Subject: FW: 5 The Dene Hurst Green

Kelly Holt Team Lead Hyndburn, Pendle and Ribble Valley **Highway Development Control Highways and Transport** Lancashire County Council www.lancashire.gov.uk

Drwg No
1424-PL06E

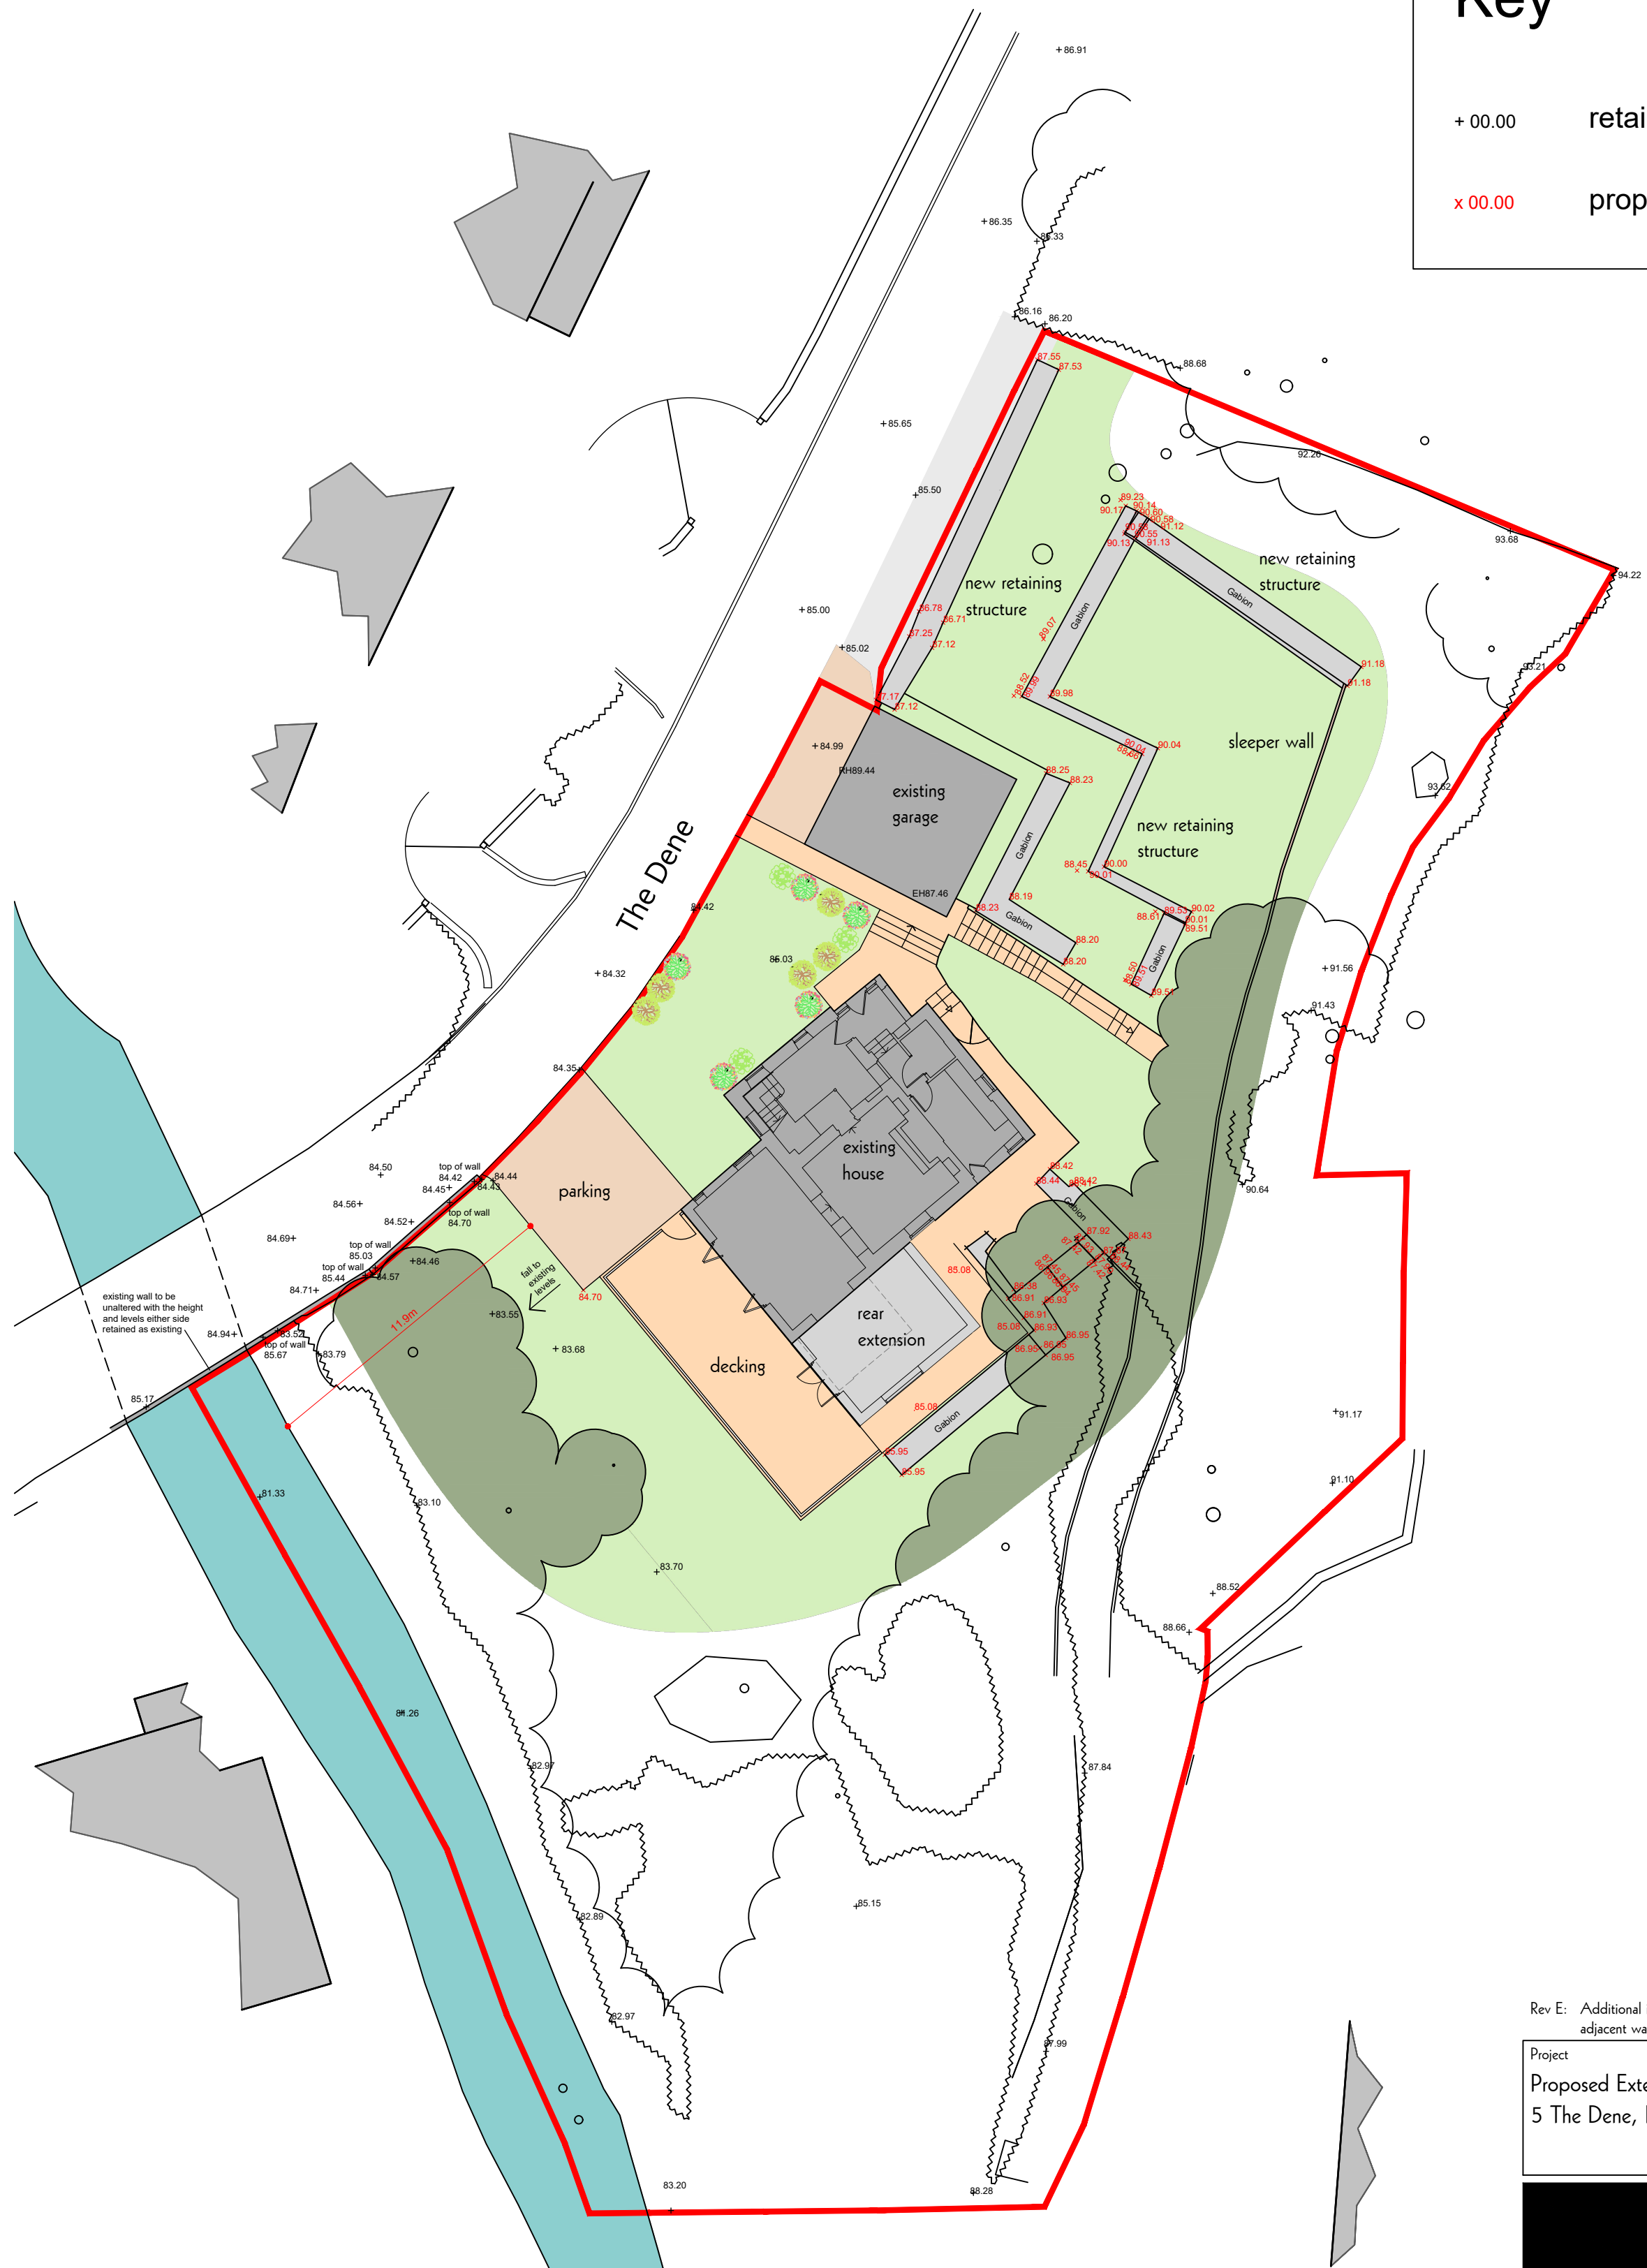
Thanks for the additional information for the retaining wall.

Essentially we would request further information from the applicant to confirm that the structure has been designed and constructed by a suitably qualified structural engineer.

This is satisfactory.

There is no objection to the proposal, the condition as stated on the original response is still required.
